Havering
LONDON BOROUGH

London Borough of Havering (20025659) – Response to Rule 17 Request to Make Changes to the Original Application (PD-020)

Having considered the Applicant's responses in Table 3.1 of REP7-029 to the comments LB Havering made at the recent Targeted Consultation concerning Change 8, we would welcome confirmation using Defra Biodiversity Metric v 2.0 that the quantity of compensatory woodland planting for this additional loss of priority habitat has taken into account the fact that The Grove lies within the Ingrebourne Valley SMI.

**Fig 3.1 - HE Indicative alignment of amended Grove Farm egress (Change 8)**

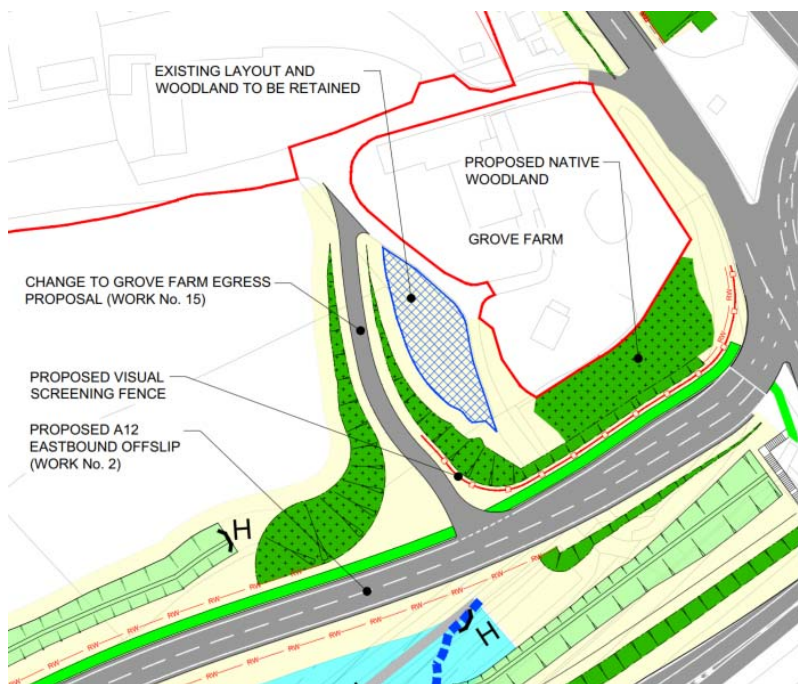
We therefore suggest that this should be confirmed by submission of the metric calculations to support the HE view of significance of this effect, as it is not obvious that this information has been considered in the calculations.

This evidence would inform whether the change falls within the assessment of the Environment Statement (ES) or not, however impacts on designated sites should be within scope. If the outcome does not change the significance from slight adverse then LB Havering would consider that this change does not affect the assessment of the ES.

LB Havering would consider that Change 8 does not constitute a material change to the Application.
